Re: Response to CGS Review Comments  
Overlook at Homestead – Filing No. 1  
El Paso, Colorado  
Entech Job No. 230677

Ref: Entech Engineering, Inc., Revised date November 13, 2024. *Soils and Geology Study, Overlook at Homestead – Filing No. 1, Elbert Road, El Paso County, Colorado.* Entech Job No. 230677.

Colorado Geological Survey, dated October 21, 2024. *EP-24-0022\_2 Overlook at Homestead Filing No. 1, Review Comments by the Colorado Geological Survey.*

EP-24-0022\_2 Overlook at Homestead Filing No. 1  
File Number: SF2425  
Location: Section 27, T11S, R64W, 6th P.M.  
39.0681, -104.5456

SITE PLAN/TESTING LOCATION MAP
OVERLOOK AT HOMESTEAD, FILING NO. 1
PT OVERLOOK, LLC

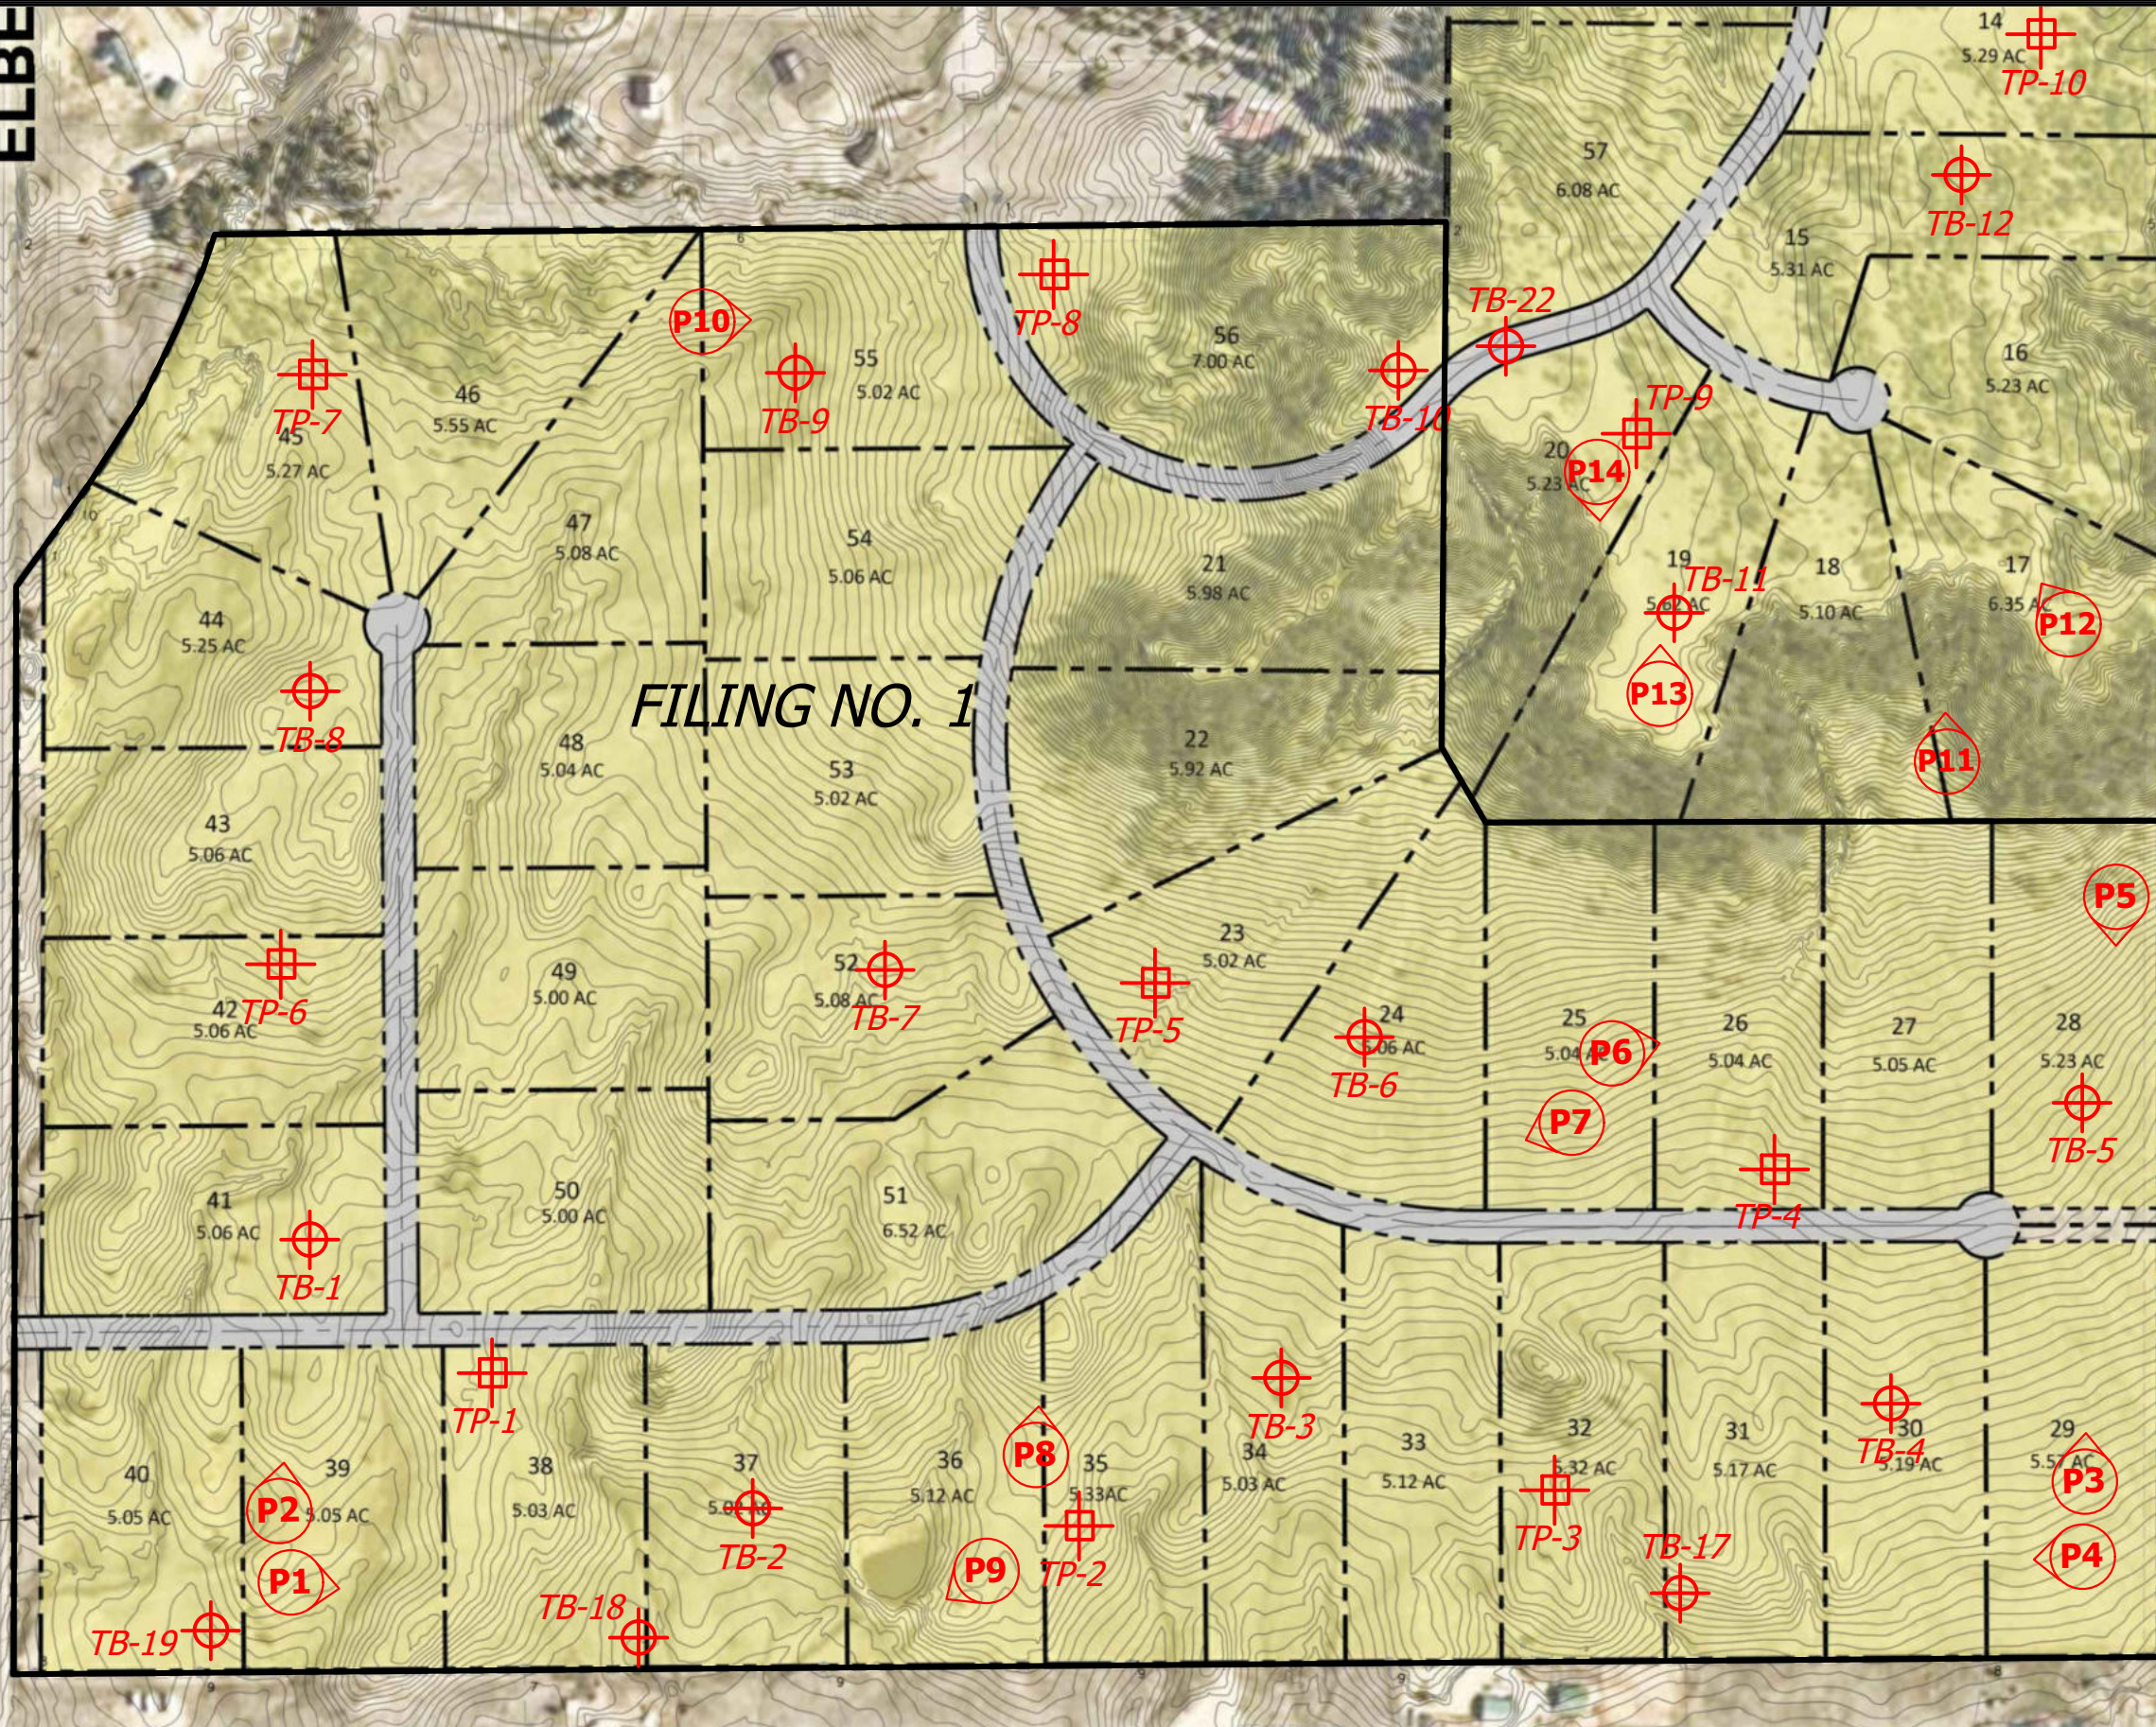
**Rockfall and potentially unstable slopes.** Entech identified potentially unstable slopes along the mesa with rockfall hazards associated with the rock outcrops. The lots listed on Entech's site plan and the final plat (Edward-James Surveying, Inc., June 5, 2024) are different; **Entech must update their site plan with the correct lot layout for Filing No. 1.** Based on the final plat, Lots 18-26 include rockfall and potentially unstable slope hazards. Entech recommends (p. 10) "A minimum setback of 30 feet from the crest of the cliff/steep slopes." CGS agrees with Entech that these areas can likely be avoided or mitigated due to the size of the lots (~3 to 5 acres). **CGS recommends that the lots that contain these hazards be listed and that the setback from potentially unstable slopes and "no build easements" associated with rockfall hazards be noted on the plat.** Site improvements must not be located within areas mapped with hazards/constraints.

**Debris fans/debris flow susceptibility.** Based on debris flow susceptibility mapping, drainages originating from the steep mesa are areas of debris flow hazards. Although the site is not within a defined floodplain, the drainages with the site may be affected by erosion, flooding, sediment-laden flows, and erosion following heavy precipitation. CGS agrees with Entech (p. 9): "Due to the material type and steepness of the slopes, the potential for significant erosion and sediment-laden flows originating along the heads of these drainages in the southeastern portion of the site following significant precipitation events exists." Also, "Drainage culverts and other drainage infrastructure should be adequately sized for the potential sediment-laden flows." Erosional setbacks from any drainage/channel within the site should be established along with site grading that provides positive surface drainage and BMPs for stormwater. **The lots affected by debris flow hazards include Lots 11-23 (based on the updated final plat lot layout). CGS recommends that the county require the lots that include debris flow hazards to be noted in the final plat.** CGS reviewed the final drainage report for Filing No. 1. **We recommend that the bulked flow dynamics associated with hyperconcentrated flooding emanating from the**

**Entech Response to Comment (Rockfall):** Figures 3, 4, and 7 have been updated to show the correct lot numbers for Filing No. 1. Lots impacted by the Rockfall and Potentially Unstable Slopes within Filing No. 1 include Lots 18-26. These areas should be identified as no-build areas. Encroachment should only be allowed after specific analysis for each condition on individual lots.

**Entech Response to Comment (Debris Fans):** Figures 3, 4, and 7 have been updated to show the correct lot numbers for Filing No. 1. Lots impacted by the Debris Fan/Debris Flow Susceptibility include Lots 11-23. These lots should be identified with the potential for debris flow hazards. Mitigation measures should be based on bulked flow dynamics associated with hyperconcentrated flooding for 25 and 100-year storm events.
